Fire Marshal Division

Re: 107 W. Front St.
Lillington, NC 27546

Application Number SFD1810-0037

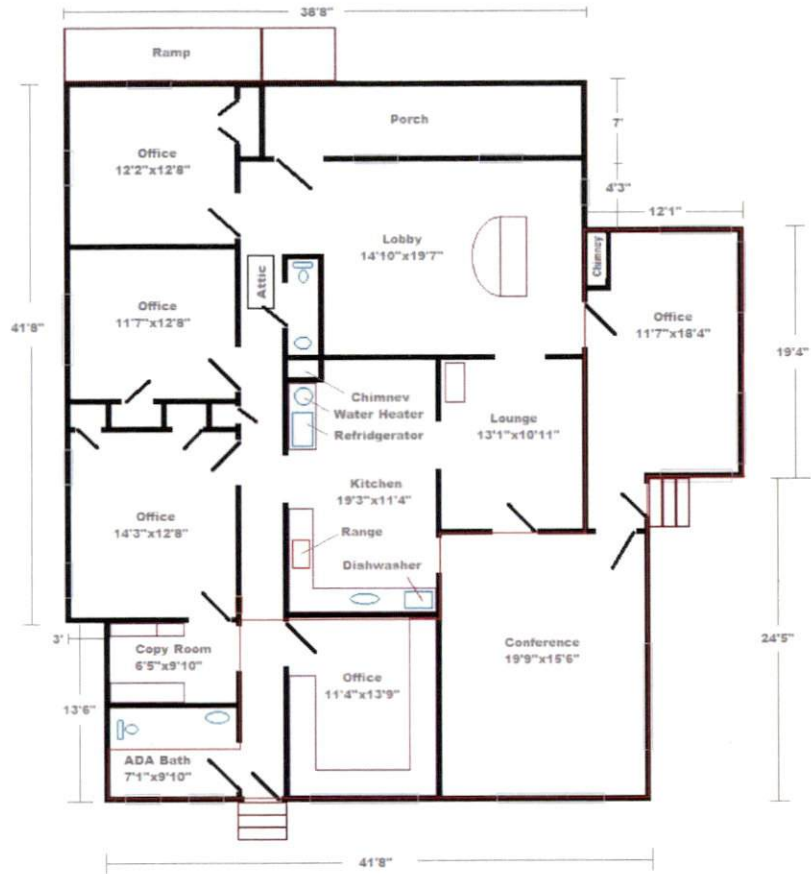
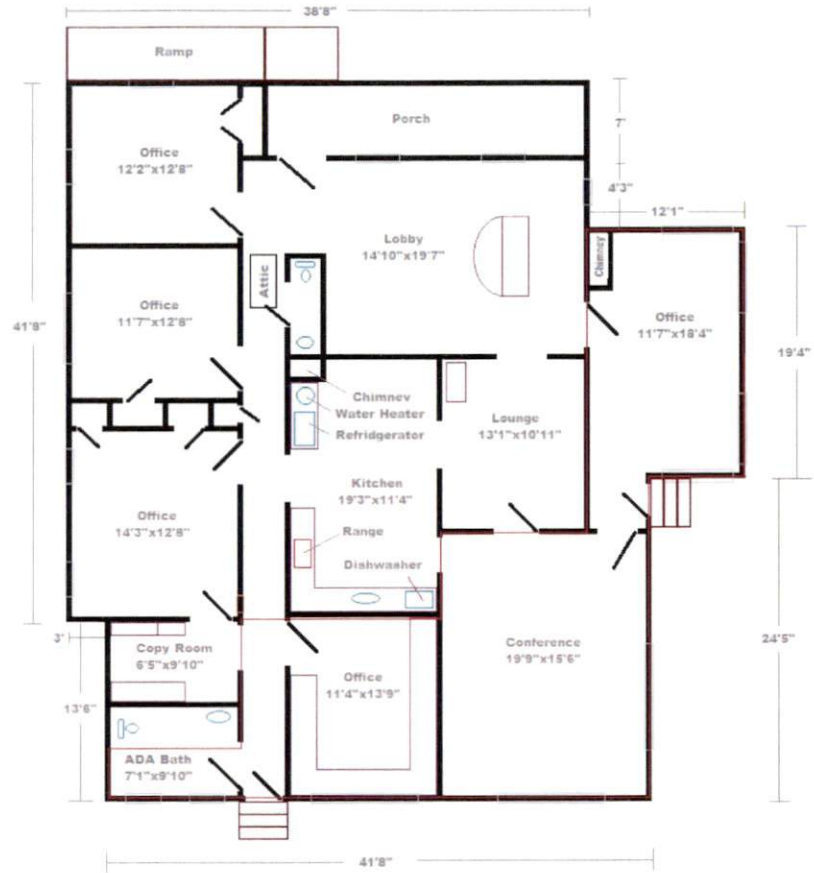
- **505.1 Physical Address**
 - The physical address of the building shall be posted in a conspicuous place so that it can be seen on approach from the road, access road, and/or parking lot.
 - The numbers used to make up the physical address shall be at least 6 inches in height.

- **Fire Extinguishers**
 - Fire Extinguishers shall be 2A:20BC and shall be placed with a travel distance to not exceed 75'
 - Fire extinguishers are to be mounted no higher than 5' above the finished floor.

- **1006.1 Illumination Required**
 - The exit discharge shall be illuminated at all times the building spaces served by the means of egress is occupied.
 - Illumination level in all areas of the means of egress shall not be less than 1 foot-candle at the walking surface and shall have emergency power supply.

- **1008.1.1 Size of Doors**
 - The minimum width of each door opening shall be sufficient for the occupant load thereof and shall provide a clear width of 32 inches.
